STATE OF NORTH CAROLINA
DEPARTMENT OF TRANSPORTATION

Addendum No. 1

RE: Contract # C204558

REPLACE BRIDGES #16 &17 ON US-701 OVER CAPE FEAR RIVER.

PROJECT REFERENCE NO. 15806.1009011	SHEET NO. 2A-4
ROADWAY DESIGN ENGINEER 	PAVEMENT DESIGN ENGINEER
DOCUMENT NOT CONSIDERED FINAL UNLESS ALL SIGNATURES COMPLETED	
ICE of Carolinas, PLLC 4505 Falls of Neuse Road, Suite 110 Raleigh, North Carolina 27609 Phone: 919-822-0353 License #: P-9999

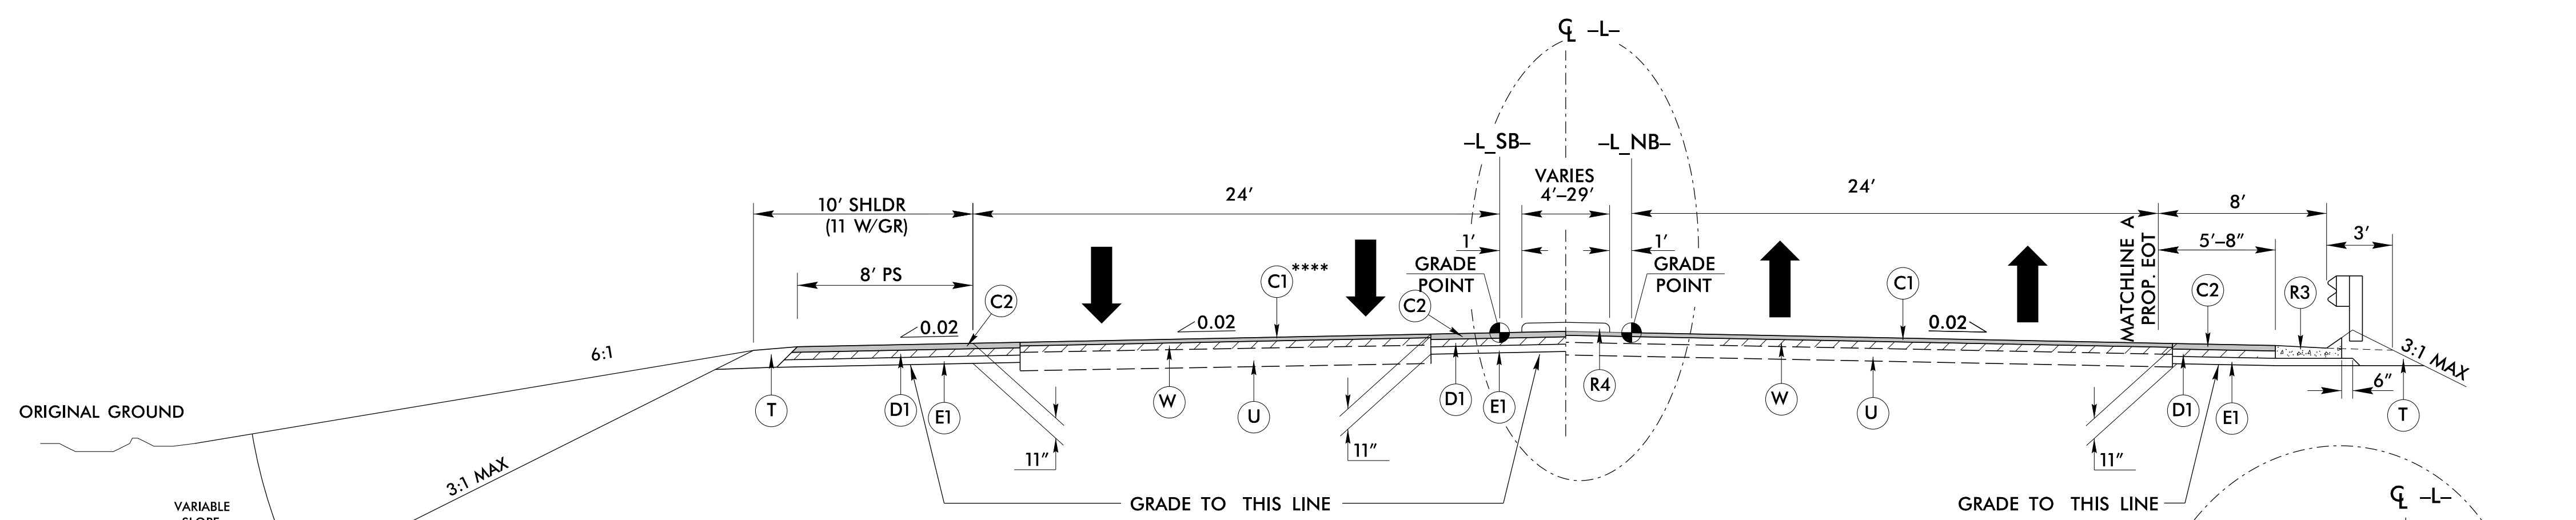
Sheet No.	Revision
4 &5	Revised to show NB bridge removed
5	Revised to show updated Rock Buttress limits and buttress completed by others
6	ROW revision on parcel 5 for access road
8	Revised profile sheet to show updated Rock Buttress limits and buttress completed by others
2A-1 thru 2A-4	Revised typical sections and corrected the WBS number
2G-2	Rock Buttress detail - Revised detail and quantities
2G-4 thru 2G-18	Revised Rock Buttress Cross Sections with new limits of rock buttress
RW02E-1	Table for ROW MARKER IRON PIN AND CAP added
RW04	Replaced Ex. RW offset call with actual footage for PDE 110+49.24 and PDE 113+40.00
RW05	added STA. and Offset for Existing R/W jogs. Ex. R/W 116+49.22 and 116+49.19
RW06	added R/W box Sta. 129+24.33 to Sta. 131+64.00 added STA and Offset for Existing R/W jogs. Ex. R/W 129+23.16, 129+24.66, 129+26.91, and 129+28.85 Replaced Ex. RW offset call with actual footage for R/W 131+64.00 and PDE 132+06.00
